**Response to Planning application from Hertfordshire County Council (T and CP GDP Order 2015)**

District ref: 6/2021/0314/FULL  
HCC ref: WH/5717/2021  
HCC received: 1 April 2021  
Area manager: Matthew Armstrong  
Case officer: Paul Marshall

22 CHURCH LANE NORTHAW POTTERS BAR EN6 4NX

AMENDED PROPOPSAL  
Erection of a 5 bedroom detached house

PROPOSED ROOF/SITE PLAN

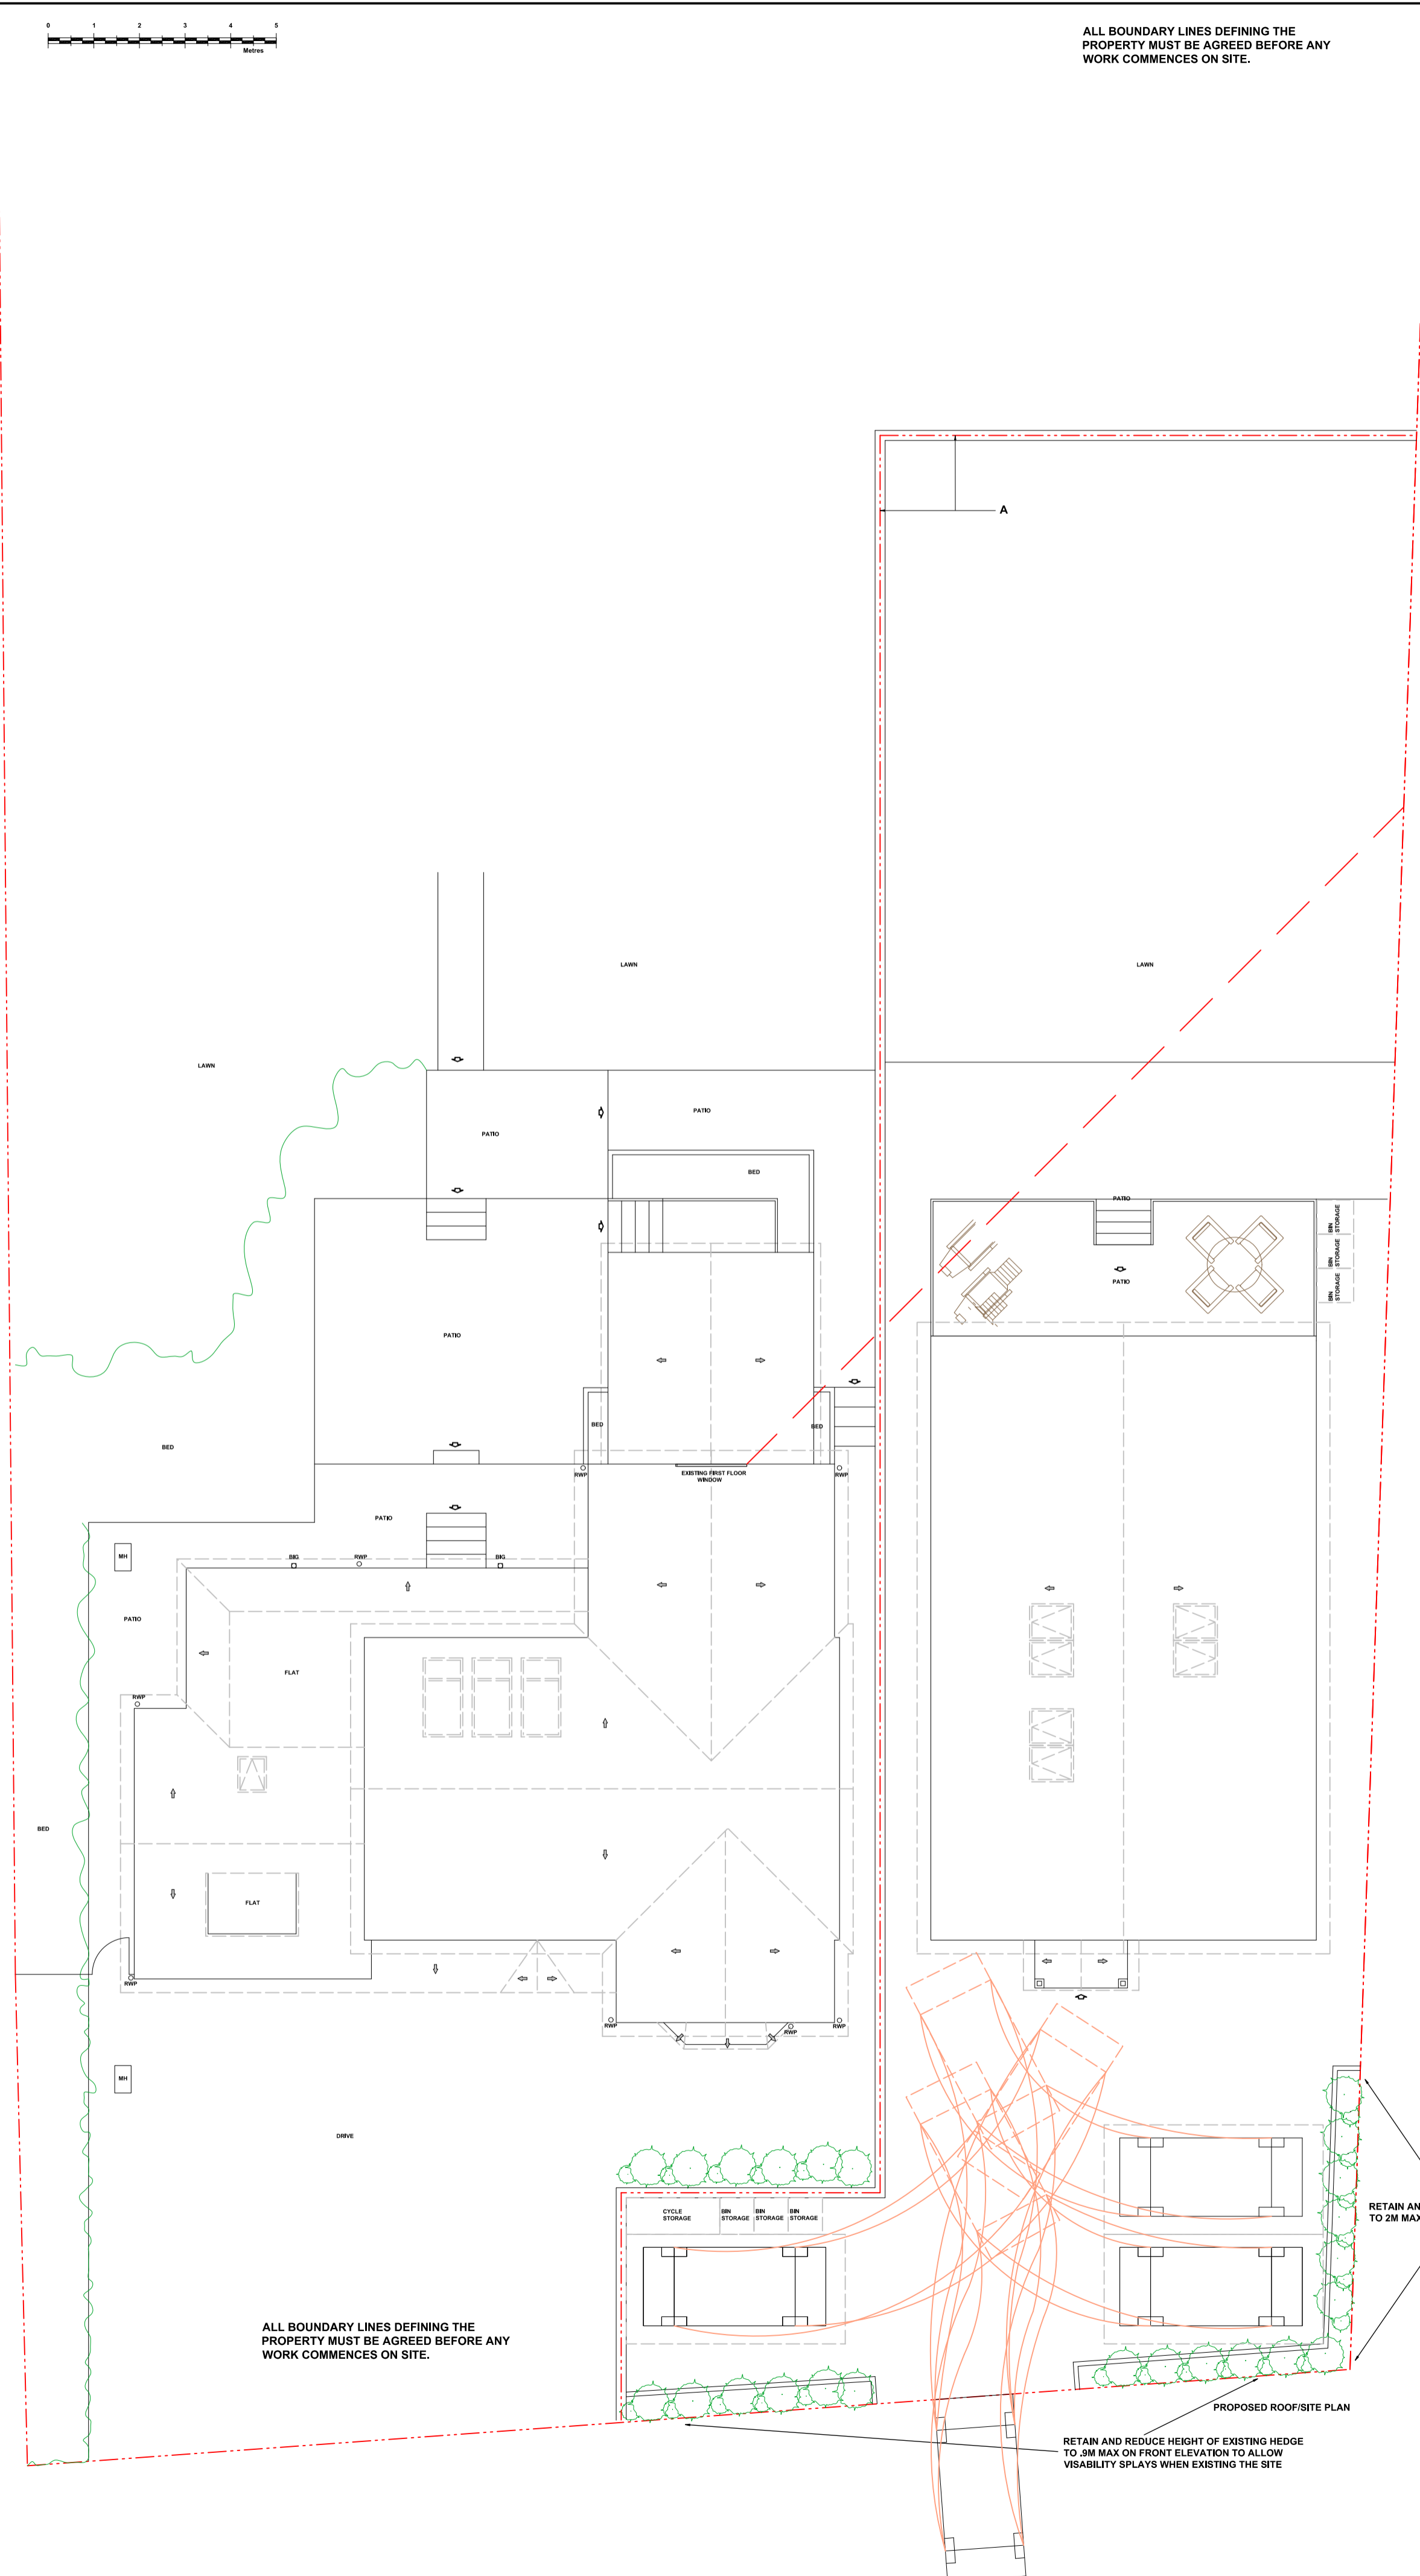
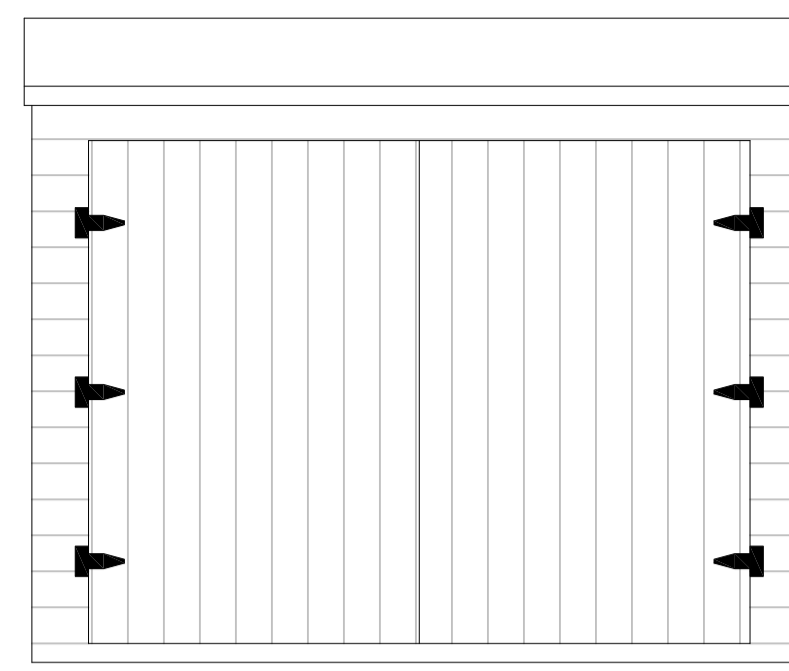
The drawing submitted for the revised tracking is the same as previous. The tracked vehicle is 4m long this must be at least 4.571m long as requested in the previous comments. Drawing 2019/1327/4 shows the tracked vehicle entering and exiting the site at an angle that would be impossible to achieve given that the road width is approx. 5m and not taking into account overgrown vegetation. As was previously asked for a detailed vehicle crossover drawing showing a visibility splay has not been provided. Drawing 2019/1327/4 does not show the lamp column which needs to be considered in terms of the new dropped kerb. The hedge shown on the plan is too high this must be .6m maximum.

The visibility splay must be measured from the back edge of the carriageway a minimum of 2m. Manual for Streets 7.7.6 states: *(reasonably built up areas) X distance should be 2.4m in most built up areas can be reduced to 2m in some very lightly trafficked and slow-speed situations.*
